CITY OF ALBUQUERQUE

August 2, 2016

**Re: Presbyterian Paradise Clinic
4588 Paradise Blvd. NW
Request Temporary 60-Day C.O. - Accepted
Engineer's Stamp dated: 10-8-15 (C12D003B7)
Certification dated: 7-29-16**

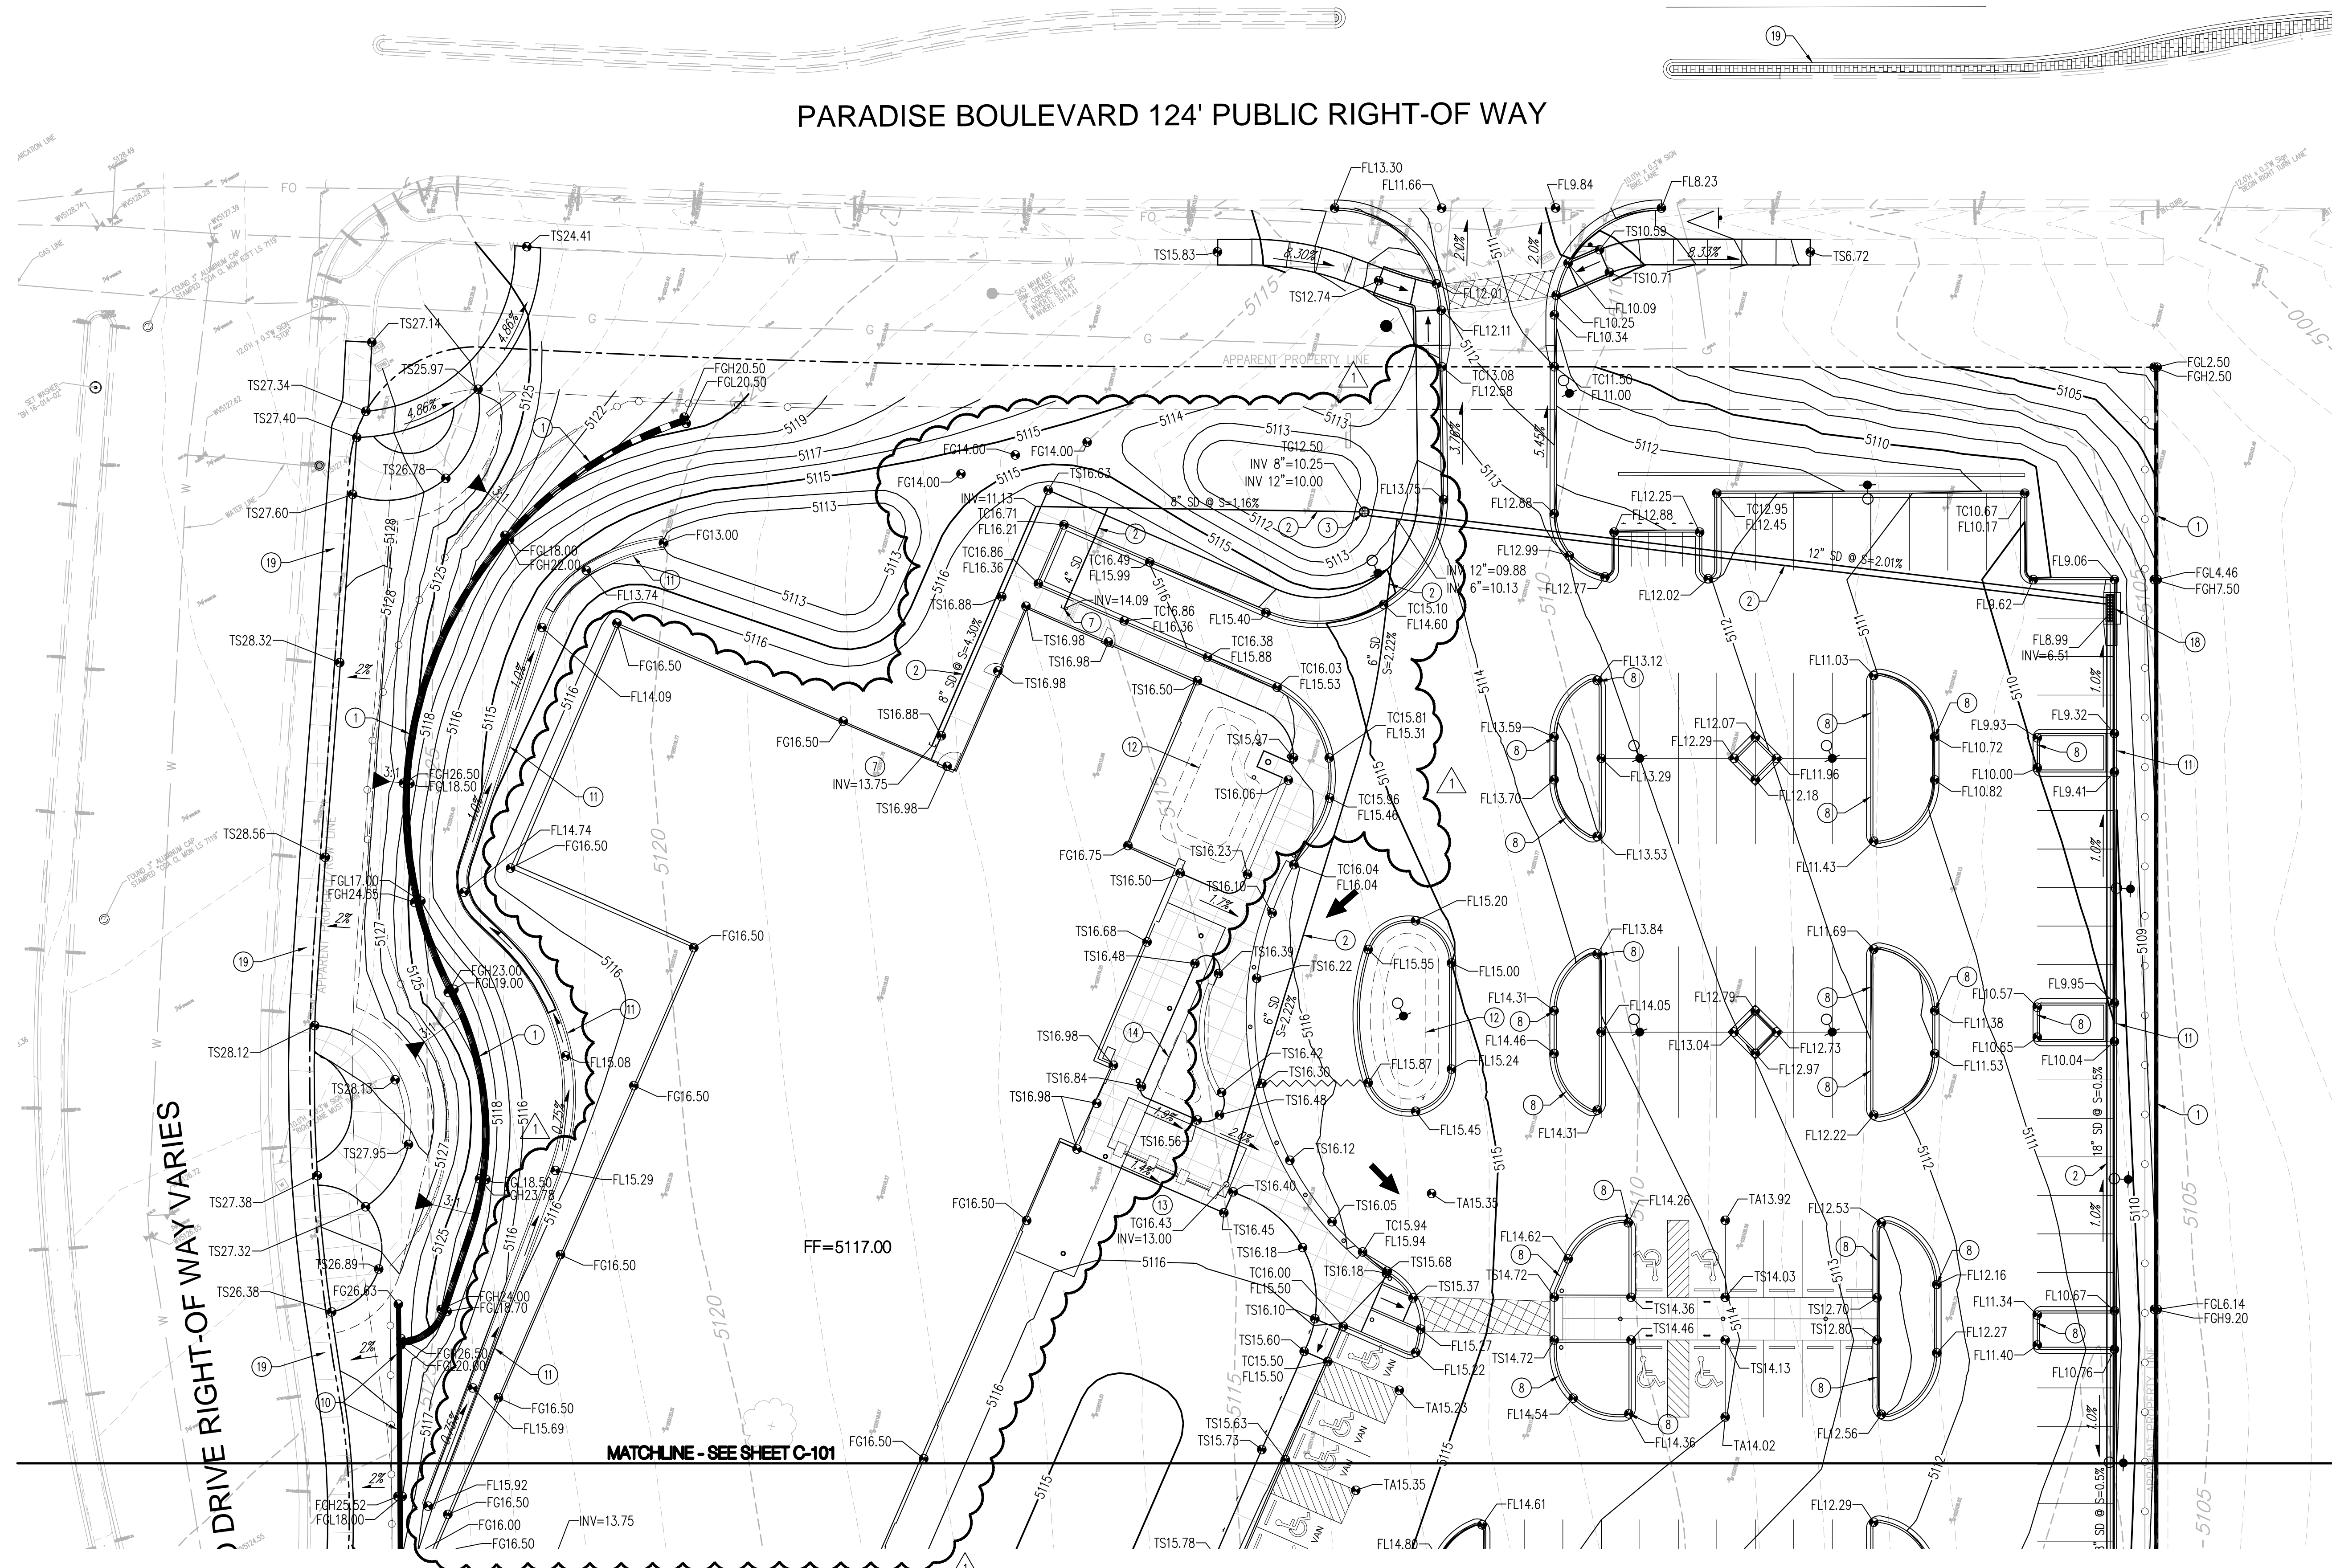
- All ponds must be landscaped
- Key note #12, landscape berm must completed
- Three most southern diamond shaped curb stops are incomplete therefore missing the curb cuts
- 18" Nyoplast drain basin with dome is missing in SW pond
- Key note #21, concrete rundown is not flared
- Key note #16, 4" pipe sleeve thru wall for drainage is missing
